An  
Bord  
Pleanála

**Board Direction**  
**ABP-307272-20**

**WHEREAS** a question has arisen as to whether the construction of a garden room/gym to the side of the existing dwelling, is or is not development or is or is not exempted development.

Proposed Site Layout Plan
 1 : 250

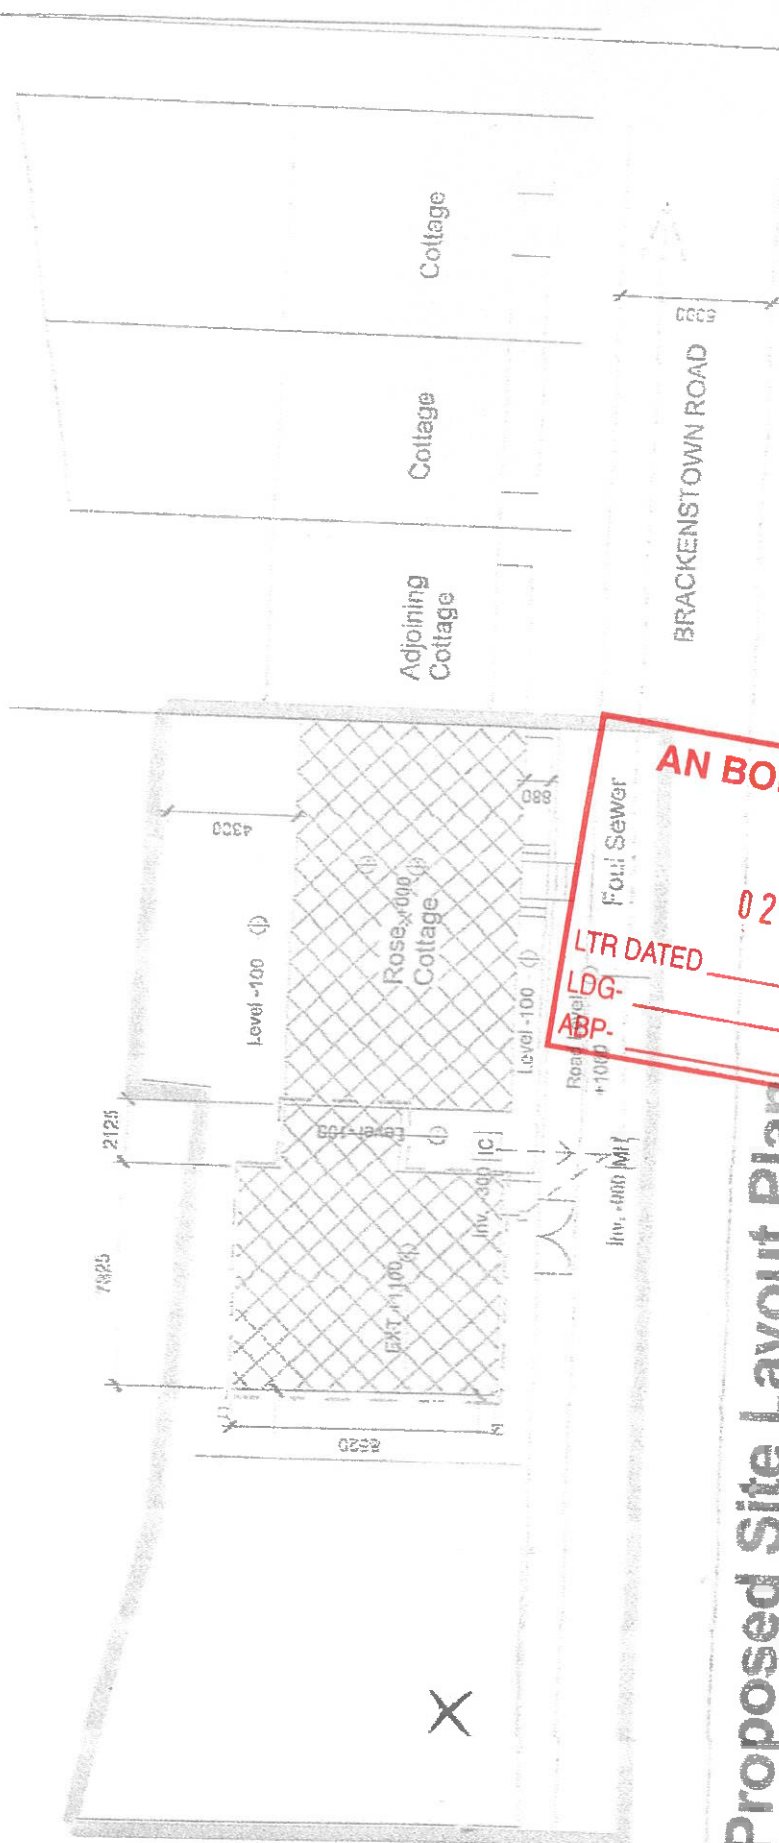
In addition, the Board considered that in the absence of a definitive drawing showing the precise position of the proposed structure within the site and by specific reference to the front wall of the existing house, that it cannot be stated definitively from the wording of the referral itself and the associated documentation presented by the referrer, that it cannot be determined that the proposed structure would be exempted development.
